Response to Planning Application

Application ref: P/170/25/DOC

Description: Approval of details reserved by condition imposed under P/114/24/RES relating to conditions 5-landscape plan, 6-public open space and 7-public play provision.

Location: Parcel Of Land 254 Pagham Road Pagham PO21 3PY

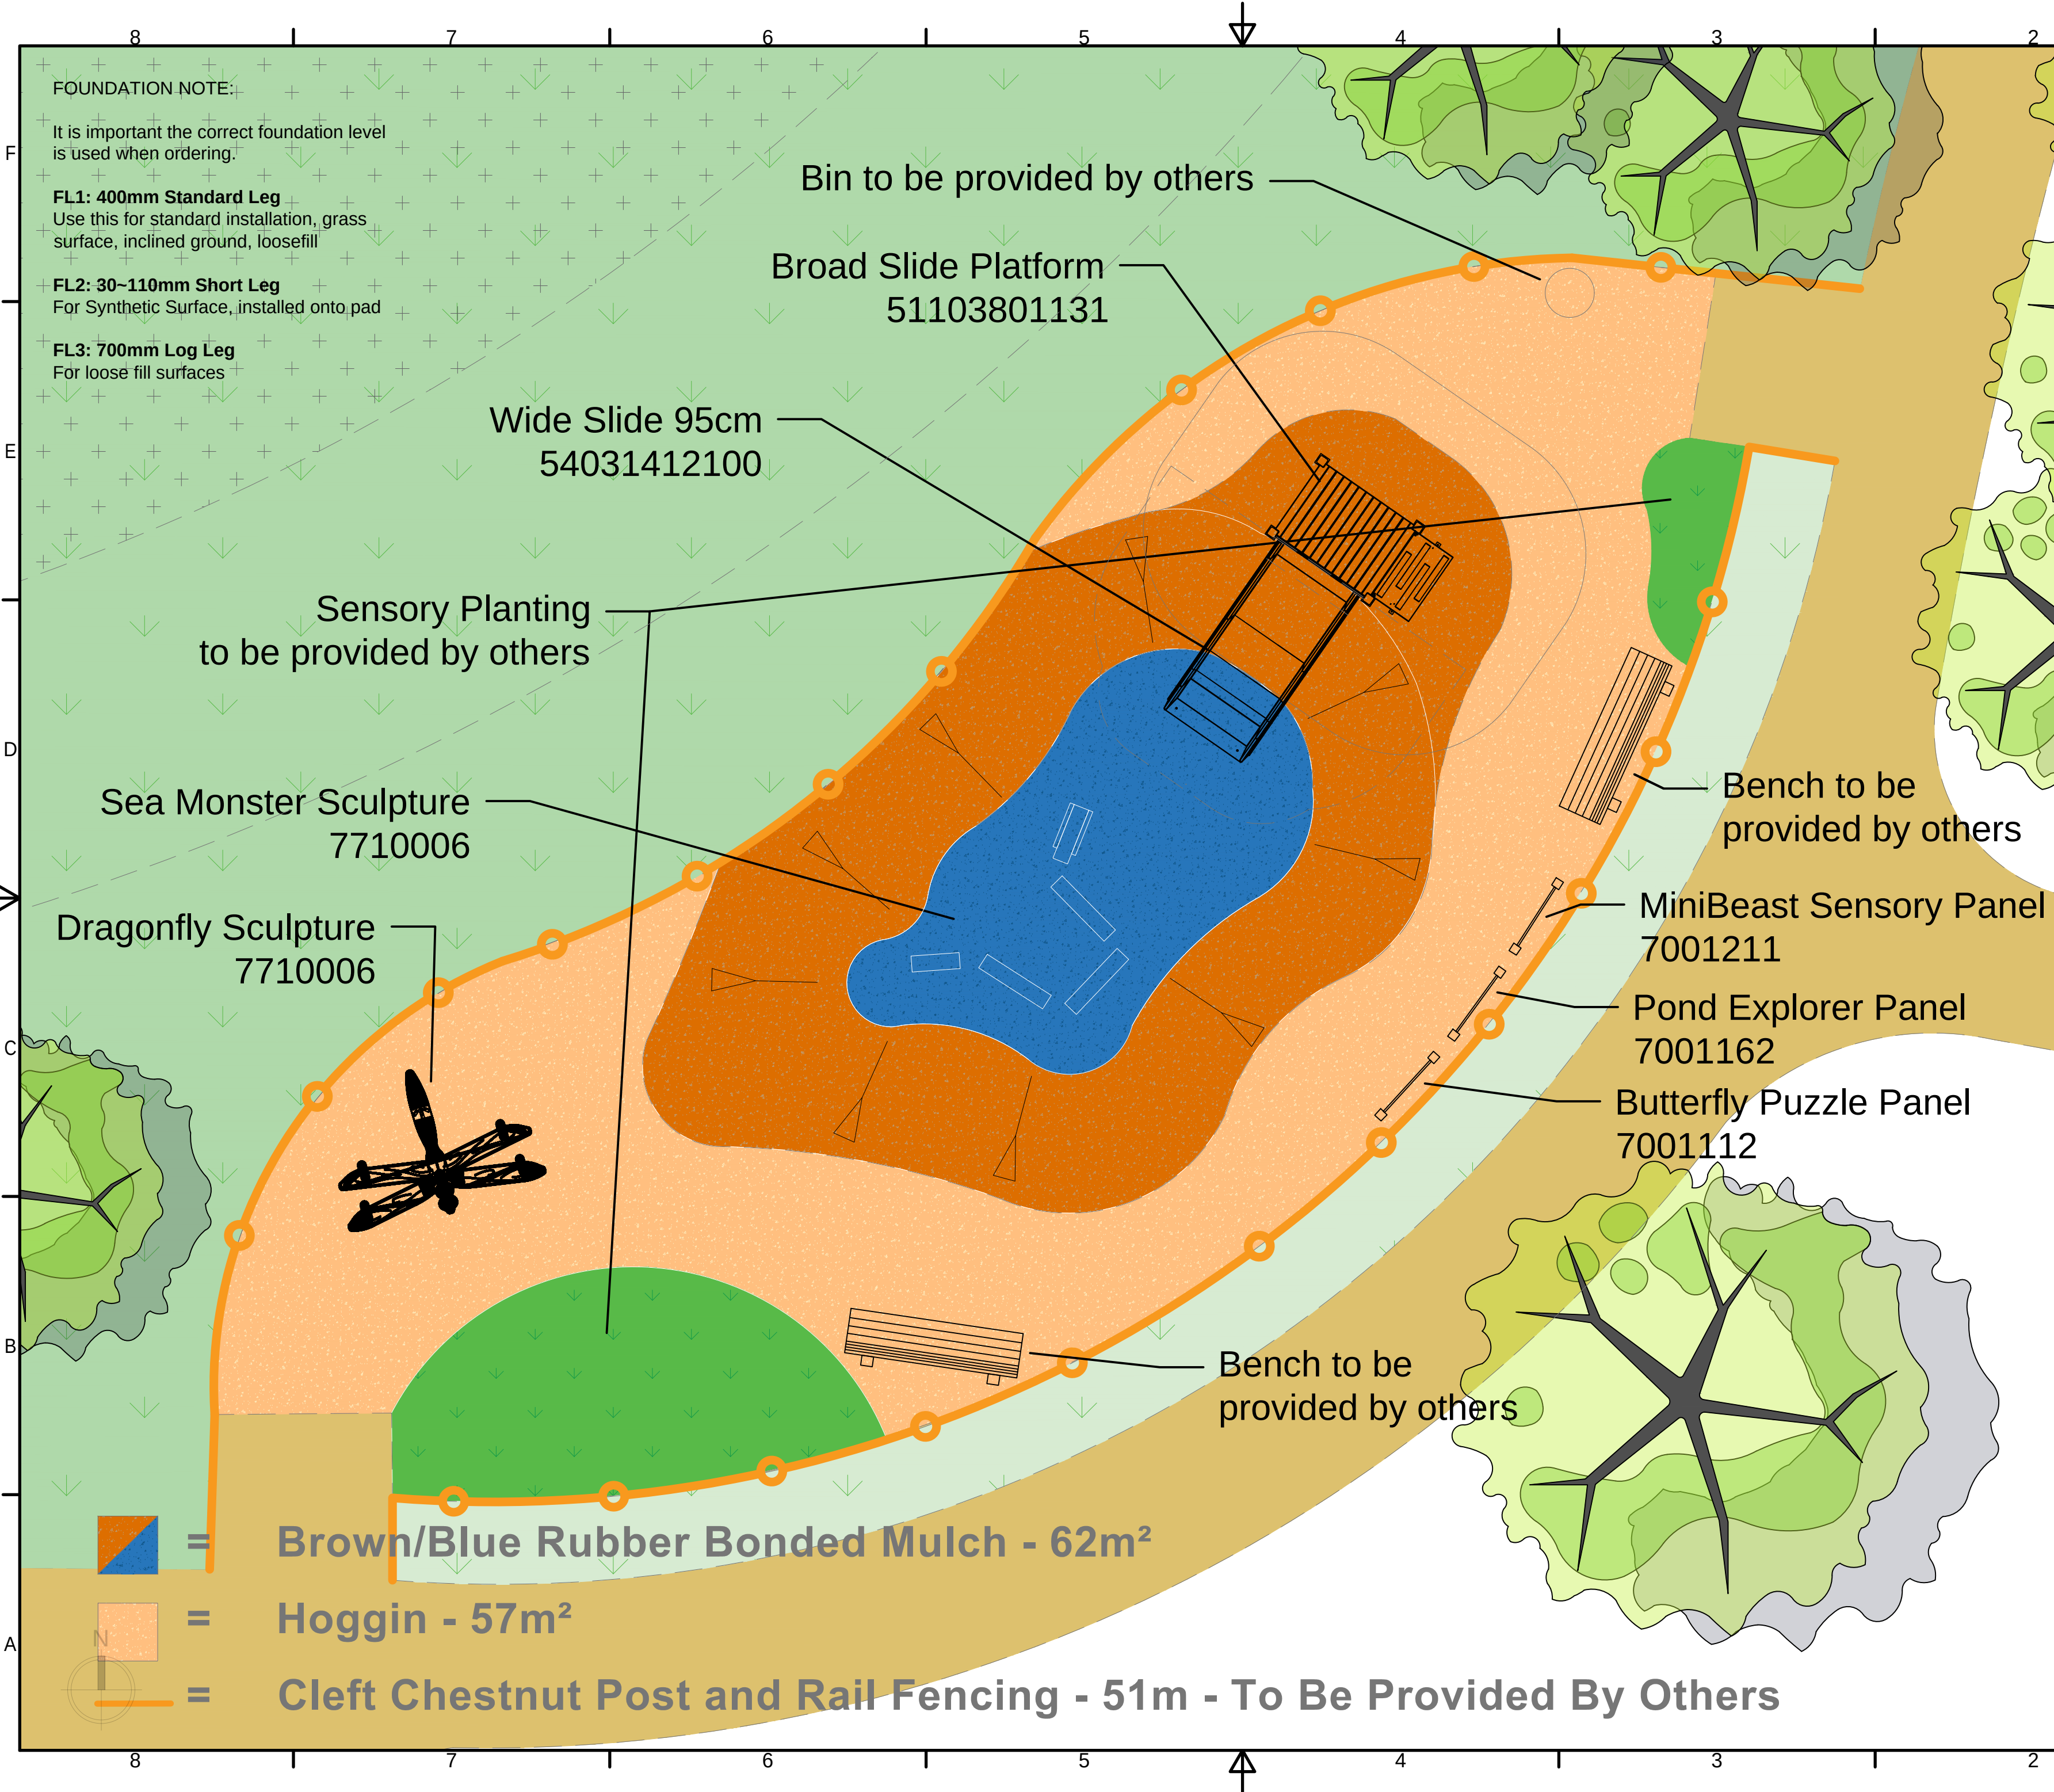
Shown to the south of the SuDS area this area was previously revised under P/114/24/RES with theme and play elements. The LAP forms a semi natural area with basic features alongside seating. A closed top bin is to be incorporated along with seating which is now shown under this application as supplied by others detailed under submitted PAGHAM POS ADDITIONAL ITEMS. Previous iteration showed a physical barrier knee rail fence between the LAP and the SuDS feature in this location, this is now shown as cleft chestnut post and rail fencing (further specification recommended to be submitted for clarity)

The detail submitted under this P/170/25/DOC under drawing PAGHAM LAP 70010150 REV E contains play pieces along the general theme Magic Pond, detail is lacking as to what is included. Specification needs to be included re the Sea Monster Sculpture and how this works with the theme? The centre of the LAP area appears to be enclosed by a mounded brown rubber crumb bund only accessed by a slide but no ground level/flat exit shown from this feature which would be recommended. Clarification needs to be submitted to show cross section of this feature/height of this feature.
